From: Sue Howell <Sue.Howell@arun.gov.uk>
Sent: 13 June 2025 10:13
To: Planning.Responses <Planning.Responses@arun.gov.uk>
Cc: Simon Davis <Simon.Davis@arun.gov.uk>
Subject: Planning Consultation on: Y/32/25/PL

Response to Planning Application

Application ref: Y/32/25/PL

Location: Land West of Bilsham Road Yapton BN18 0LA

Figure 2 - Approved Site Plan of Y/3/22/OUT

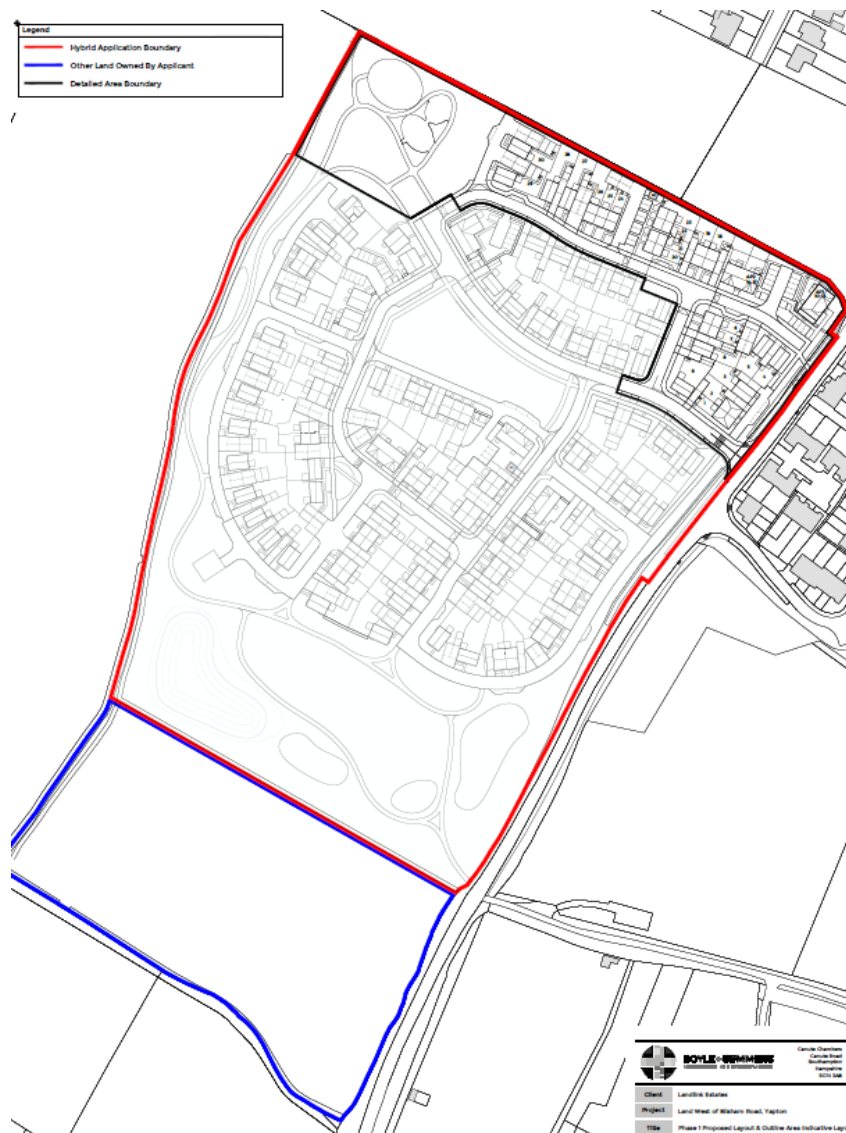
The submitted Block Plan 1100 still appears to show a much denser plot layout to the previously approved application Y/2/22/OUT which previously had a central village green at the heart of the development and greater landscape buffer areas to the periphery. The previously approved masterplan appeared to represent a more sympathetic green infrastructure offer to that shown within this application.
